Planning & Urban Development Department
Jeff Levine, AICP, Director

August 28, 2013

Re: 887 Congress Street and MMC Parking Garage –Sign Permit for the Walkway- Permit # 2013 01666

Customer Name: Maine Medical Center
 Job Description: Window Graphics for Catwalk
 Sales Rep: JP
 Drawn By: JK
 Job Number: 34419
 Revision Version #:
 Date: 7.22.2013
 File Location: J: Maine Medical Center_34419

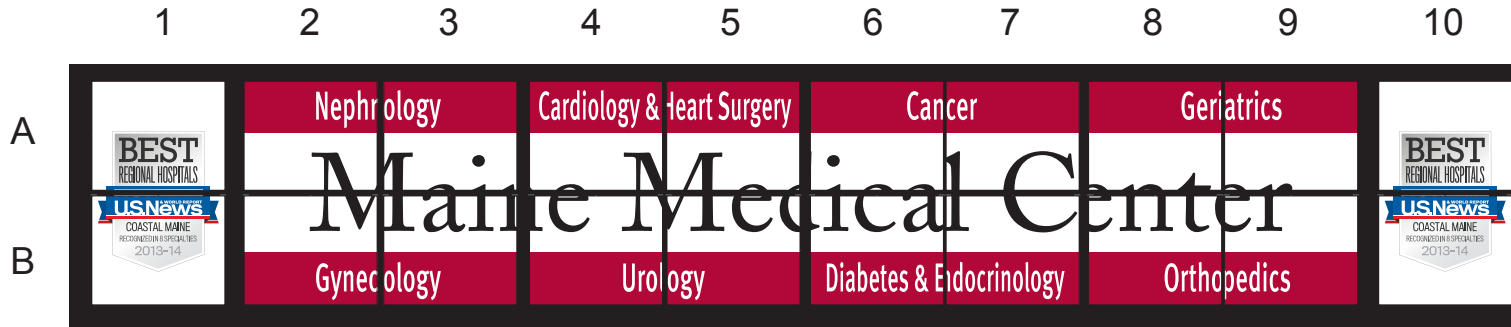
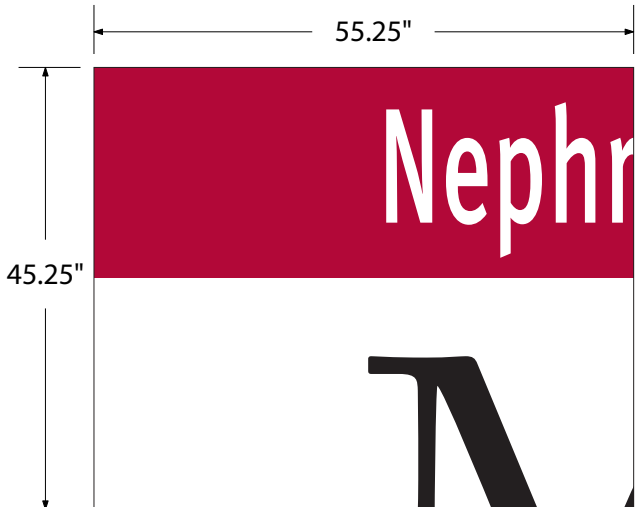
The present application for a sign is proposed to be 7.5 feet by 46 feet for a total of 345 square feet, which covers more than 50 percent of the walkway windows.

According to the above reference, all signs will need to meet the requirements of the sign ordinance and the underlining B-2 zone. Under the B-2 zone, signs cannot cover more than 50% of the sign. This sign covers more than 50% of the walkway windows.

The second issue is that no signs are allowed in the City's right-of way and this sign is in the right-of-way. The sign is also promoting the Maine Medical Center and not the medical building, thus this sign is considered at off-premises sign.

Staff Comment: This standard states the sign “shall be appropriate to the scale and character of the neighborhood in which it is located and shall be designed to suit the conditions from which it will be viewed”. As mentioned before, the architectural intention of this walkway was for a glazed, glass canopy and the size, scale, and proportion of the proposed sign will take this away from the structure. The proposed sign is of a scale and character of a billboard. It is not compatible with the neighborhood. There are no other signs in this neighborhood that are as large as this proposed sign.

Staff Comment: The walkway in itself is unique for this neighborhood but the sign does not respond to the characteristics of the structure. As mentioned above, the intention of the walkway was to have a glass window that is transparent. Even though the sign is described as translucent and not opaque, it will substantially impede the transparency of the glass fenestration and impair visibility into, out of, and through the walkway.

Thus, the request for a sign exception for the walkway at 887 Congress Street and the MMC Parking Garage is denied. I suggest that if you want to continue to pursue a sign on the overhead walkway, that you consider something considerably smaller, and architecturally integrated into the walkway design and which does not block or interfere with the transparency of the glazing. Any sign that is more substantial and visually dominant than that will be considered an amendment to the approved site plan for the walkway, and will be subject to review and approval by the Planning Board.
